**Subject:** FW: 6 Church Green West

Conversion of existing offices to 1no. 2 bedroom flat with external bin and cycle storage area, and amended means of access to second floor apartment and means of escape from ground floor offices.

CAR PARK (REAR) ELEVATION

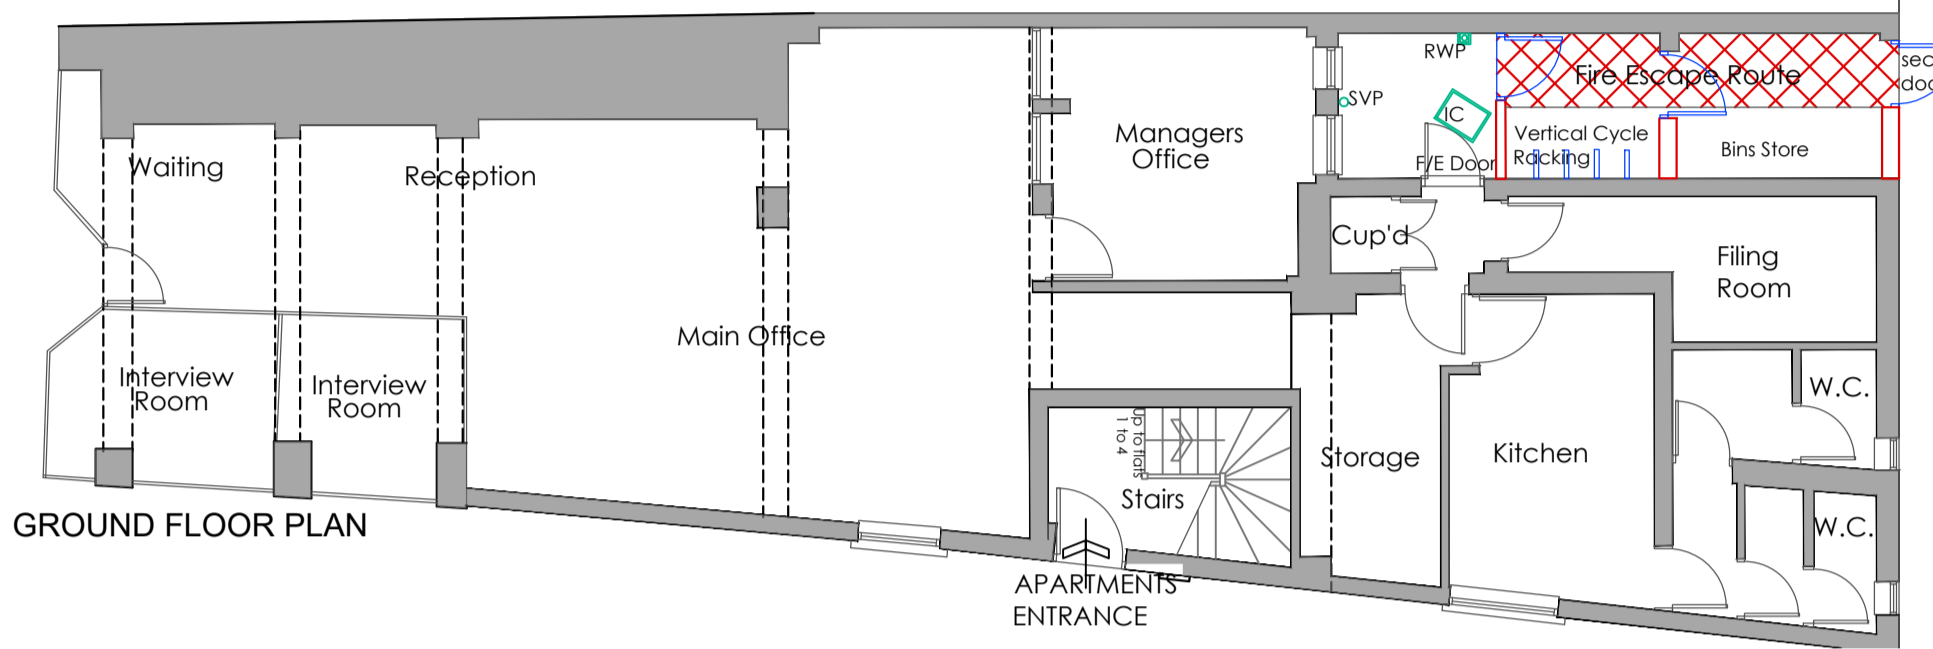
However, having looked at the revisions, given that there are only internal alterations proposed to the existing second floor flat, I would consider that the proposal is now for 1No. 2 bedroom flat and external alterations proposed on the rear elevation for the means of escape (please update proposed elevations to show this).

Please can you provide me with a revised description and revised plans to show the minor external alterations and I will then carry out the consultations for the revised scheme.

Please find attached revised drawings which indicate the new wall and door access to the rear elevation. All other elevations are to remain as existing.
